**Addendum No. 1**

RE: Contract ID C202606

**Brunswick County (BK-5129)**

Replace Fender System Bridge #14 on NC-133 Over Atlantic Intracoastal Waterway  
Between Southport and Oak Island

REVISIONS						SHEET NO.
NO.	BY:	DATE:	NO.	BY:	DATE:	S-1
1			3			TOTAL SHEETS 6
2			4

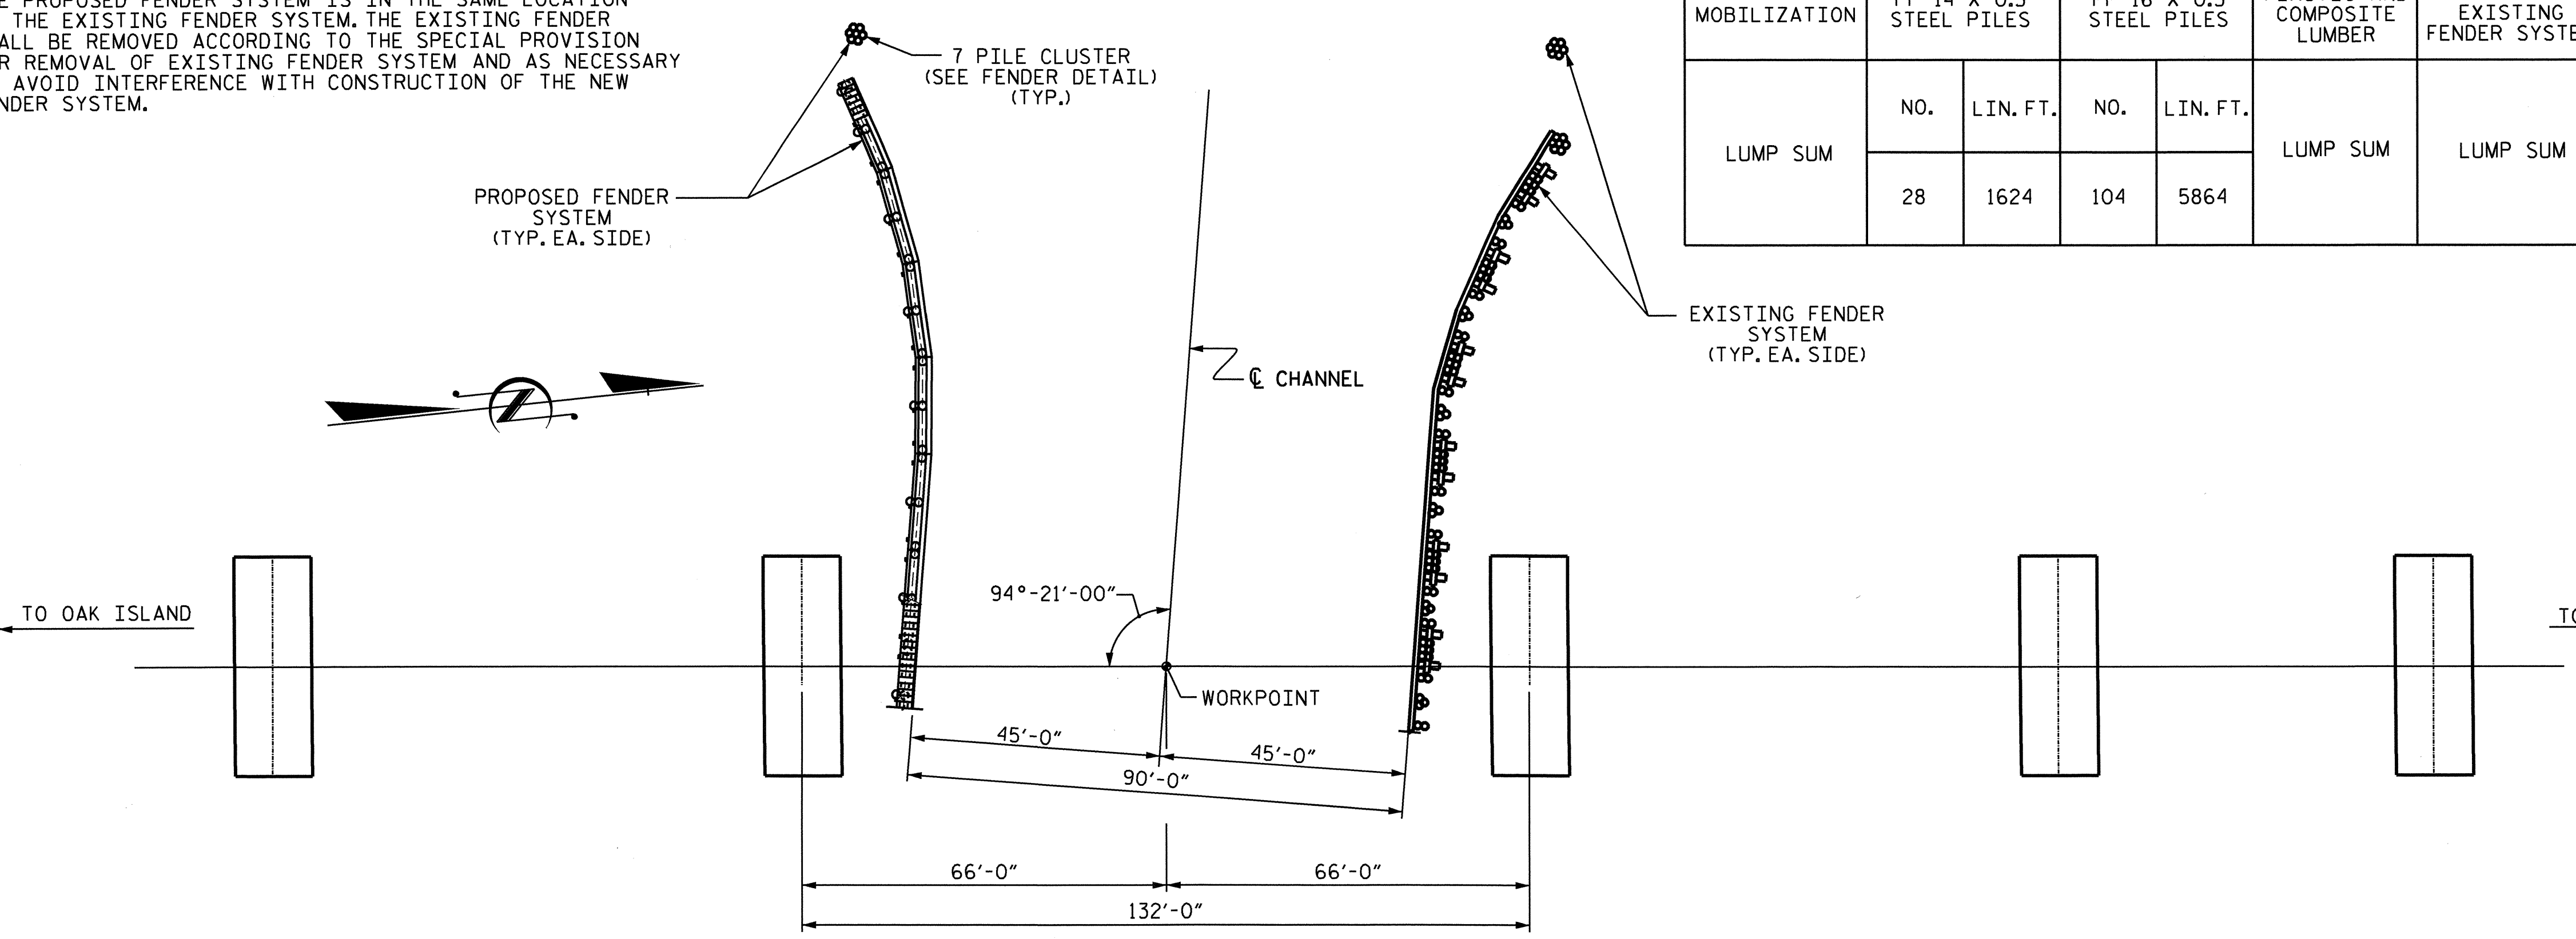
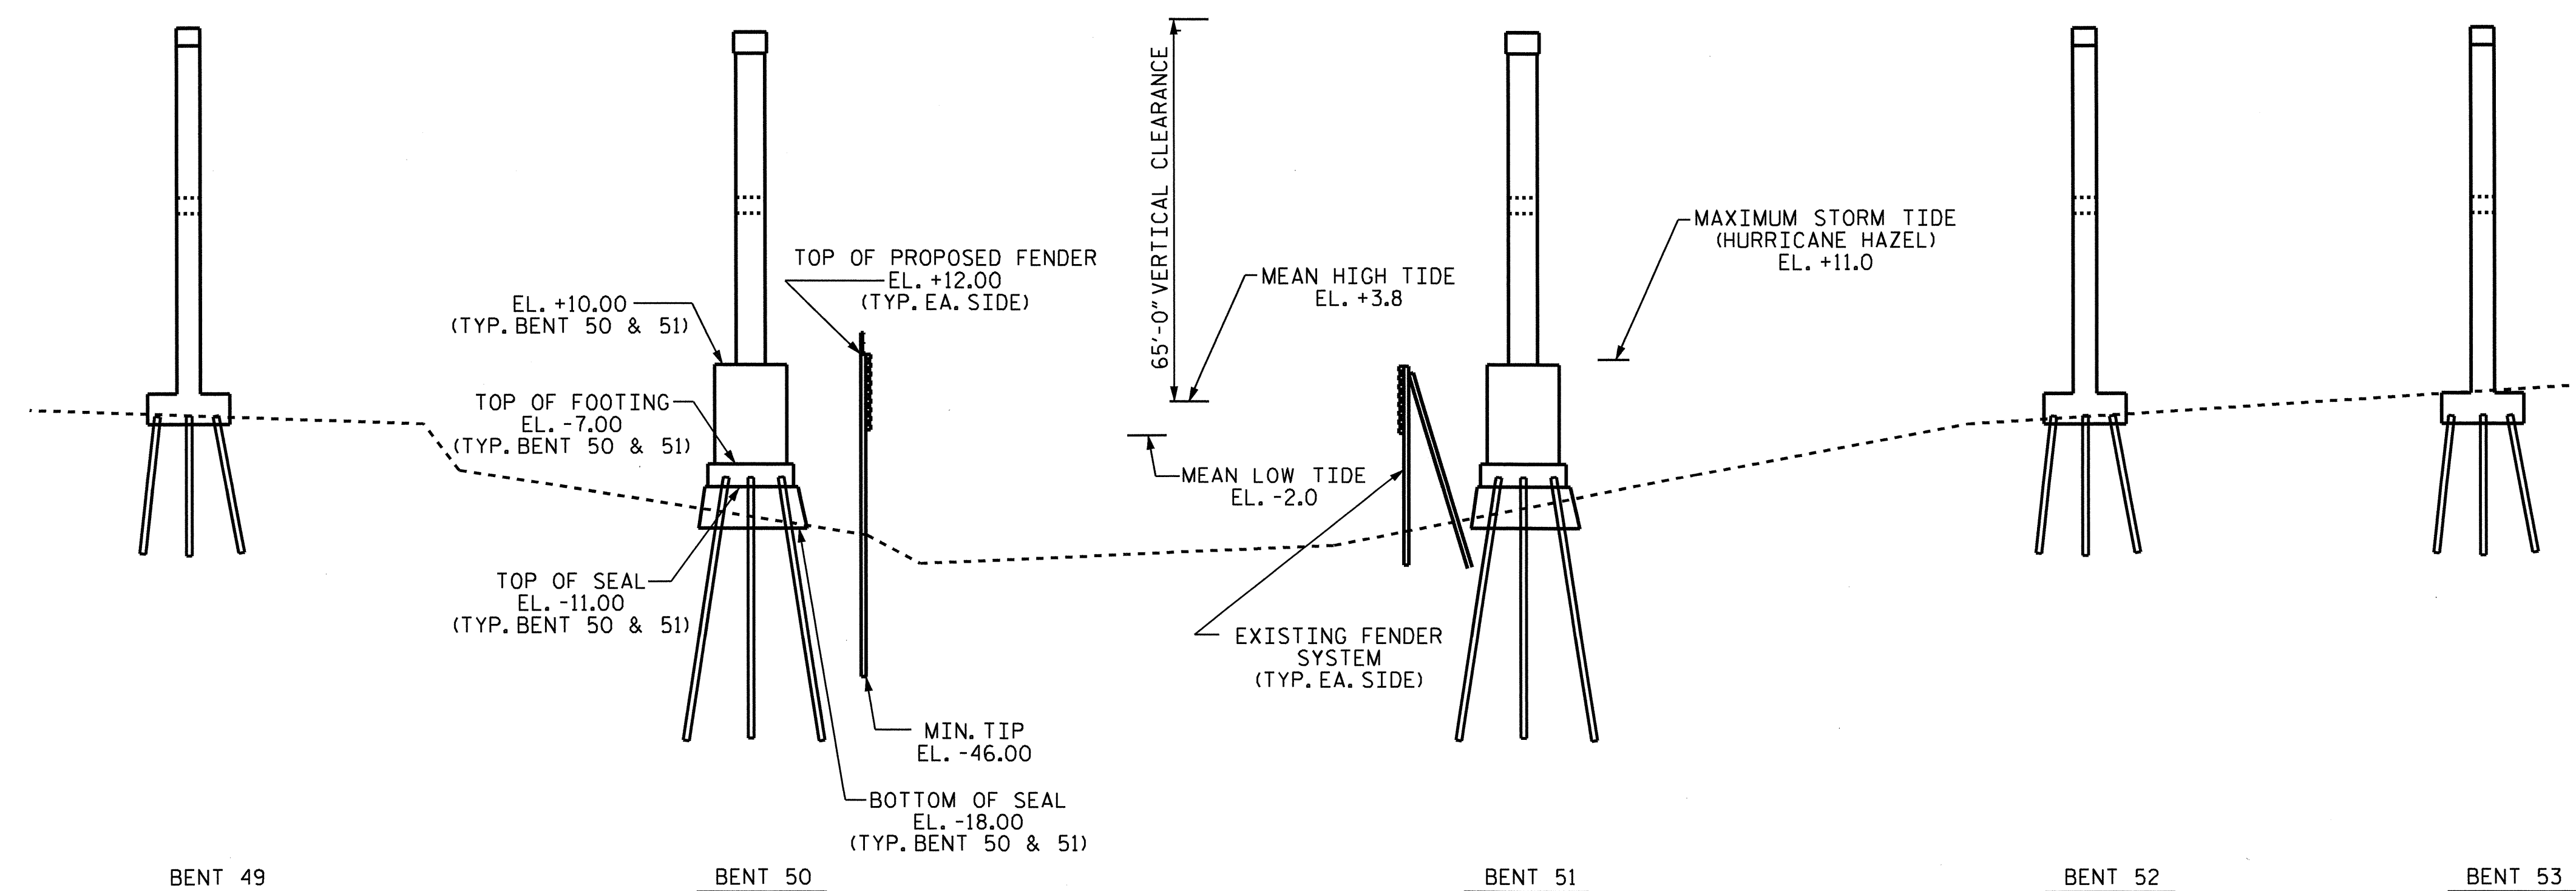
On Sheet No. S-1 the "Total Bill of Material" and the note concerning the "stainless steel bolts" has been revised. Please void Sheet No. S-1 in your plans and staple the revised Sheet No. S-1 thereto.
